**RE: Animal Humane Society Animal Park  
615 Wyoming Blvd NE  
Grading and Drainage Plan  
Engineers Stamp Date 12/23/16 (L19-D058)**

**From:** Rael, Rudy E.  
**To:** "Mike Walla (mikew@wallaengineering.com)"  
**Subject:** Animal Humane Society  
**Date:** Friday, September 23, 2016 12:30:00 PM

Based upon the information provided in your submittal received 9/2/16, the above referenced Grading and Drainage Report and plan cannot be approved for Grading Permit or Building Permit until the following comments are addressed:

GRADING and DRAINAGE PLAN

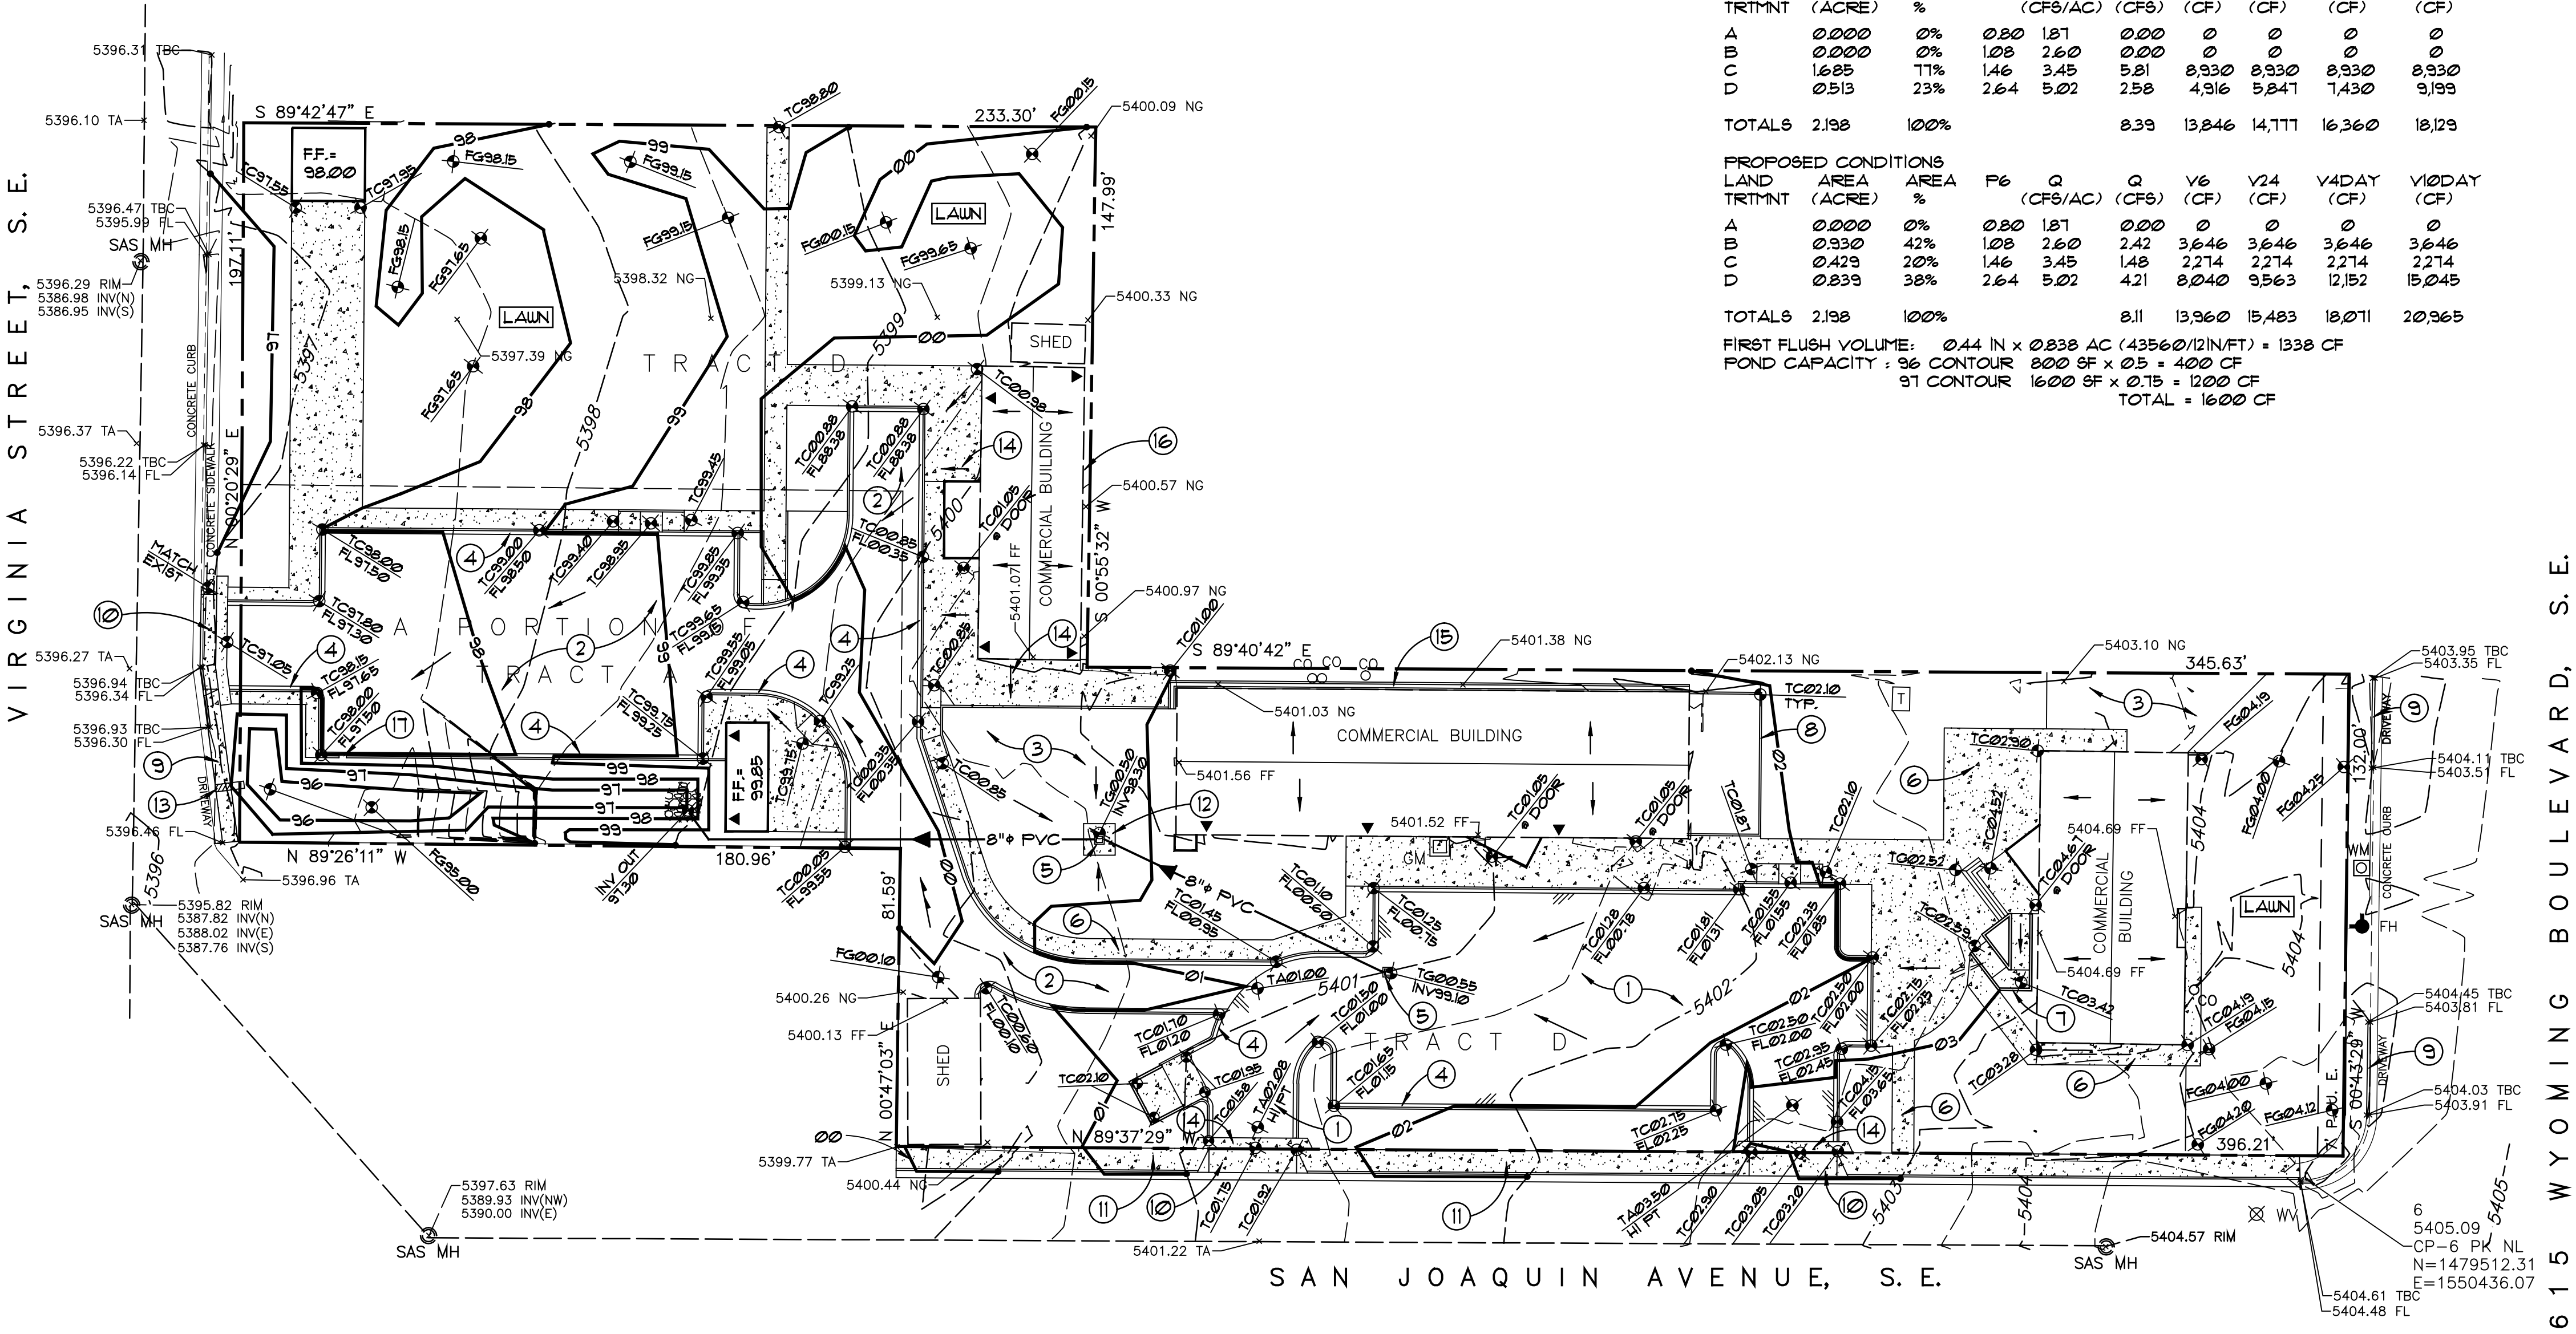
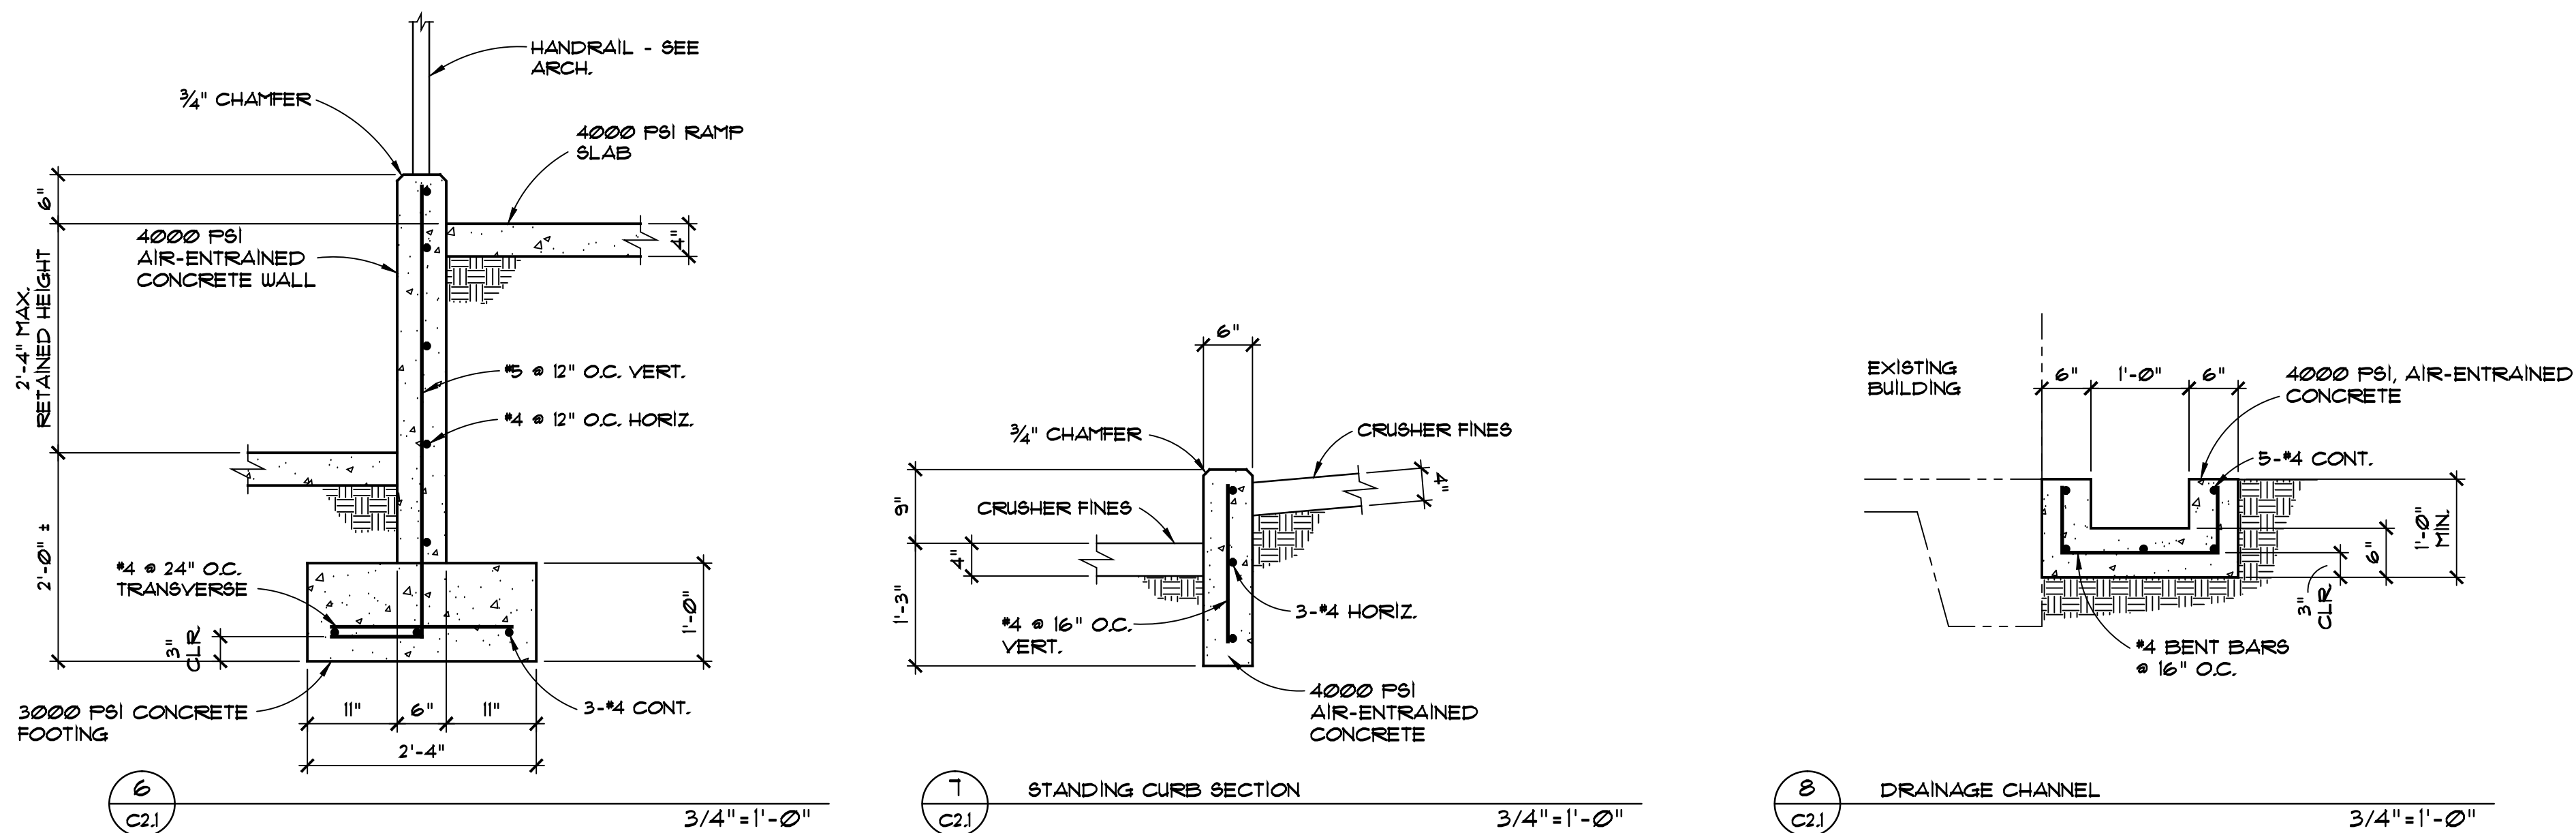
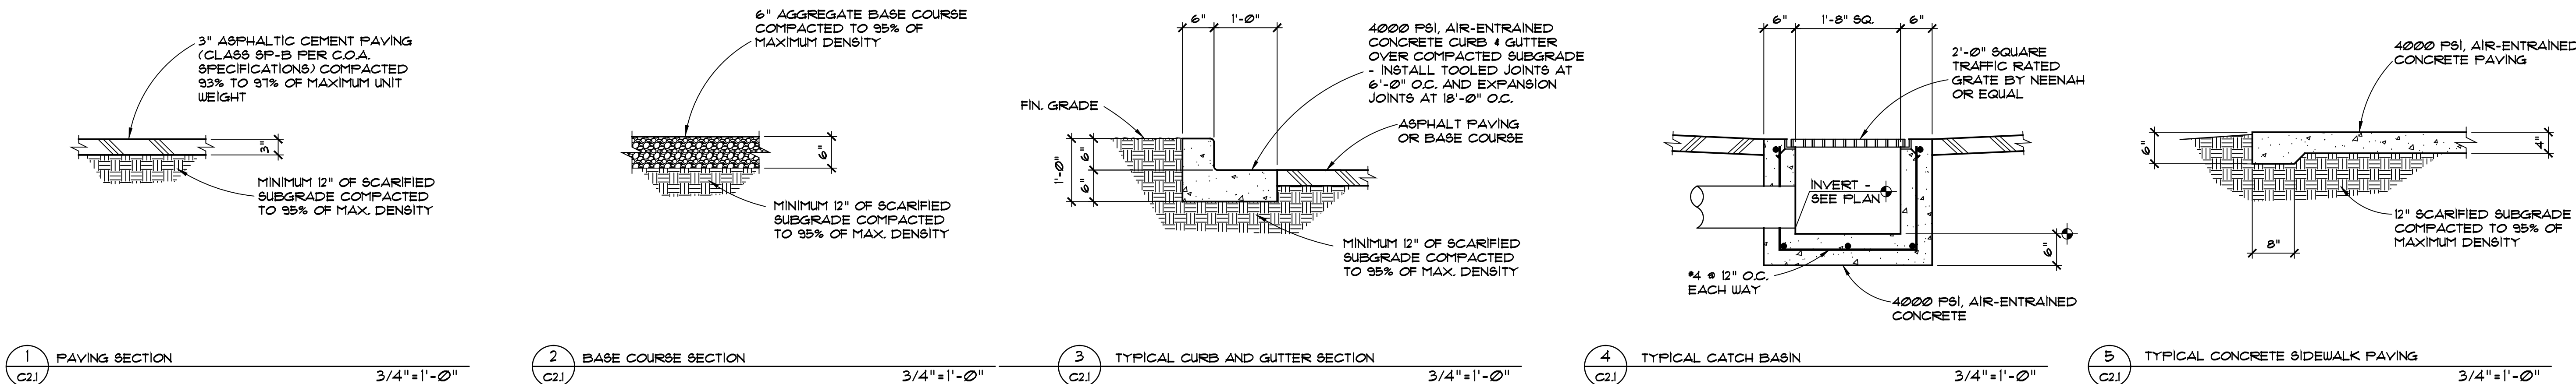
- Provide the roof flows. How will the flows navigate around the buildings?
- Provide SO-19 notes for the side walk culvert. Extend the side walk culvert 1' passed the property line.
- Show how off-site flows will be diverted around this site.
- Show how flows will not enter the SFD to the SW corner.
- Provide a curb cut opening near the driveway entrance. Slope the parking area toward the curb cut opening at FL 97.90.
- Depress all landscape areas.
- Provide an Erosion and sediment control plan or the permit if provided by another engineer.
- Provide how vehicles will navigate around the property at the SW corner of this site, there does not appear to be enough room for a double lane. Are the owners giving permission or are they allowing the animal humane society to cut through the corner of their property? Provide the written document allowing this access.

1. Roof drain locations, roof slopes and methodology for handling these flows have been added to the plan.
2. SO-19 notes were already on the plan.
3. I have modified the Drainage Narrative to clarify this issue but no significant offsite flow affects this site.
4. The paving will be sloped to create an invert directing runoff to the onsite pond and protect against overflow to the neighboring property.
5. This recommendation has been done and the plan modified accordingly.
6. Landscaped areas have been depressed as much as possible and still maintain the intended function as a dog training area.
7. The Contractor will provide this plan during the permitting process.
8. The referenced traffic lane is only intended as a single lane drive and will only be used by maintenance staff for access. There will be no public traffic thru this access drive.

# SITE PLAN

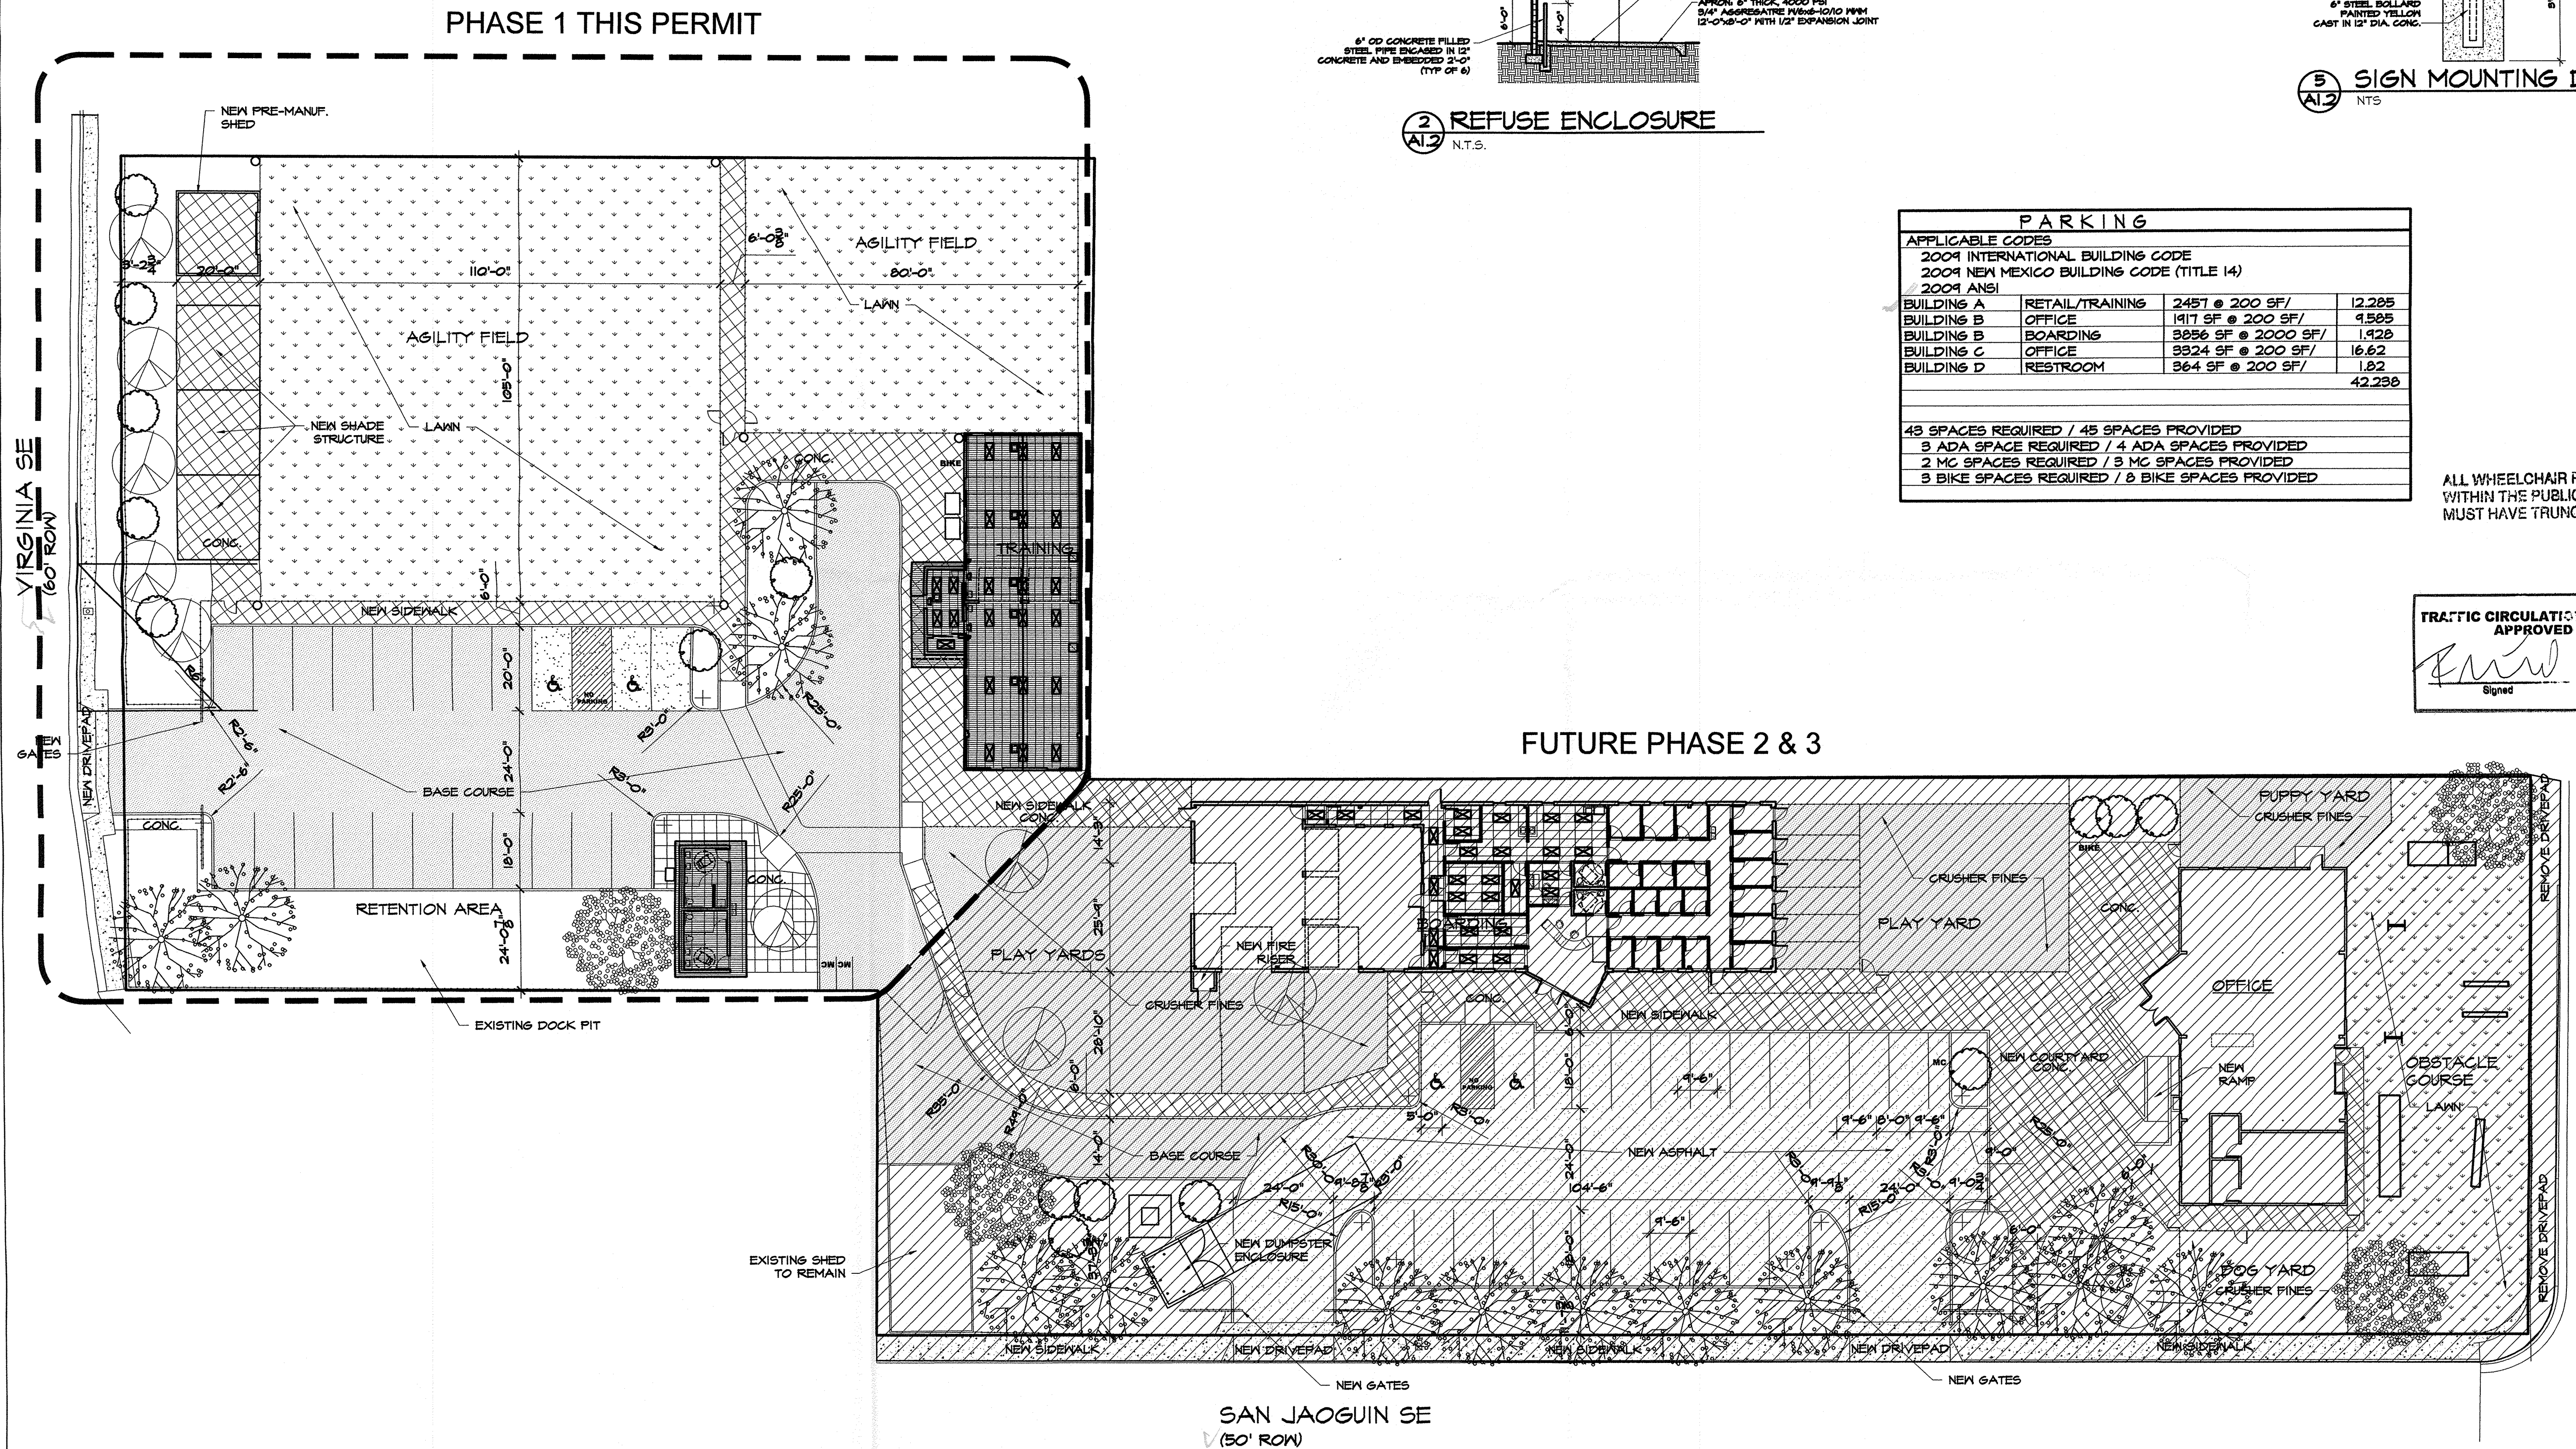
- ✓1. List the number of parking spaces required by the zoning code for each phase as well as the proposed number of parking spaces including bicycle and motorcycle parking.
- ✓2. Identify the right of way width, medians, curb cuts, and street widths on Virginia St SE.
- ✓3. Show the clear sight triangle and add the following note to the plan:  
"Landscaping and signage will not interfere with clear sight requirements. Therefore, signs, walls, trees, and shrubbery between 3 and 8 feet tall (as measured from the gutter pan) will not be acceptable in the clear sight triangle.
- ✓4. Please specify the City Standard Drawing Number when applicable.
- ✓5. Please include two copies of the traffic circulation layout at the next submittal.

**We have addressed your concerns in your letter of Nov 23, 2016.**
